## PLANNING APPLICATION REPORT

**REF NO:** M/35/08/

**LOCATION:** 26 Sea Way  
Elmer Sands  
Middleton on Sea

**PROPOSAL:** Extension and alterations to provide 3 bedrooms, bathroom, ensuite and stairhall.  
(Resubmission following M/154/07)

PROPOSED
ELEVATIONS

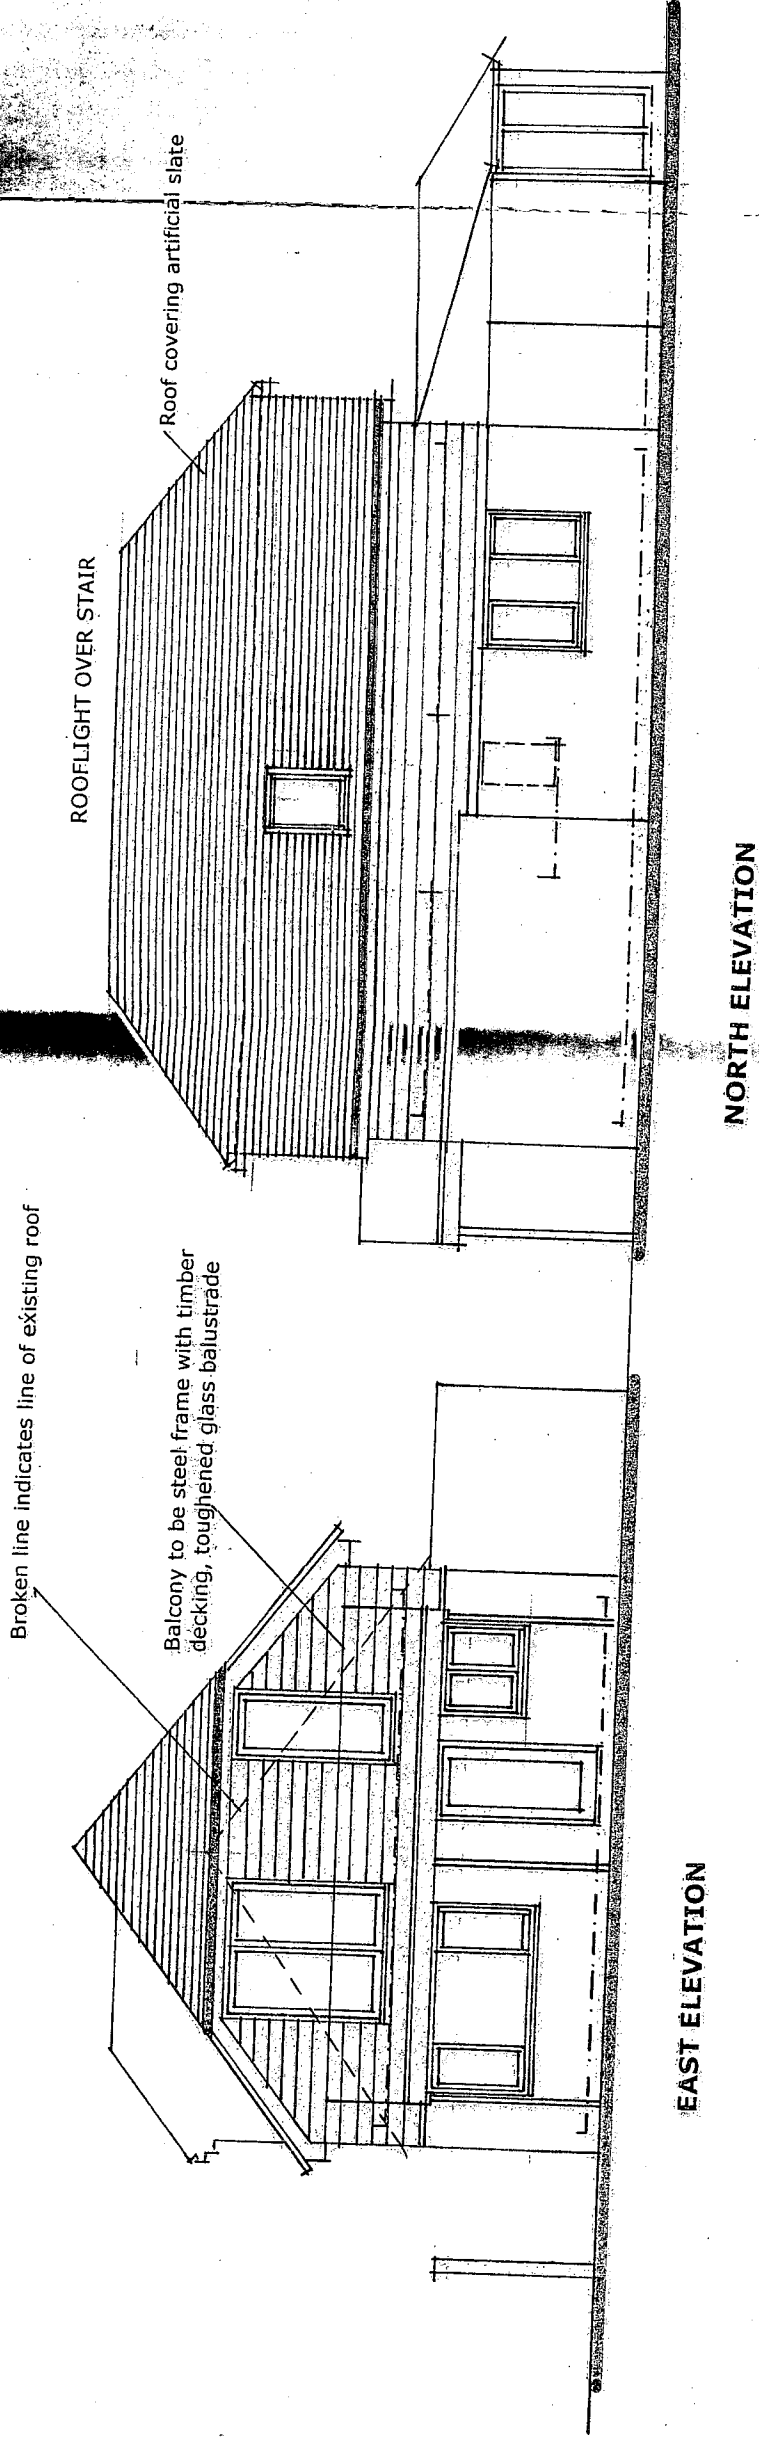
The windows on the western elevation will overlook our property. The proposed extension constitutes over development of the site when compared to the size of the plot and the adjacent properties. No provision has been made for off-street parking that may be required for a house of this type. The neighbouring property No 28 will lose light and sunlight particularly during the winter months).

Noted. The proposal would introduce two new windows at first floor level in the west facing elevation but the distances between properties mean this would not result in significant harm by reason of overlooking. Although the extension is not visually subservient to the main dwelling it is not considered that the proposal would be an overdevelopment of the site, unneighbourly to neighbouring properties or obtrusive in the street scene. For these reasons and those set out in the conclusions section of this report, the proposal is recommended for approval.

There are two windows proposed on the rear which serve the bedroom and bathroom and the bathroom window will have obscure glazing. It is considered that there is adequate distance retained between the proposal and No 1 not to cause harmful overlooking or loss of privacy to the occupiers of this property. The neighbouring property to the south No 24 is set back from the proposal and it is not considered that the dormer on the south side elevation of the proposal which serves the en-suite would cause any overlooking or loss of privacy to the occupiers of this property. A condition is to be recommended requiring that the window have obscure glazing. The neighbouring bungalow to the north No 28 which is set back from No 26 is approximately 1.5m from the application site. This property has an ancillary lounge window on the south side elevation that will overlook the proposal but due to the position of the roof light on the north elevation which serves the stairwell it is not considered that this would create any overlooking or loss of privacy to the occupiers of No 28. However, the extension may cause some overshadowing and loss of light to the occupiers of No 28 but it is not considered to be of a harmful nature to warrant a refusal. The windows and balcony area to the front of the property may create a certain amount of oblique overlooking and loss of privacy to the properties to the east of the site. However, with a distance of approximately 27m to these properties it is not considered that this would be of an unacceptable level to warrant a refusal.

- 2 The dormer window on the south elevation of the roof extension shall at all times be glazed with obscured glass and shall consist of at least two lights divided horizontally with the bottom light being permanently fixed and only the top light capable of being opened.
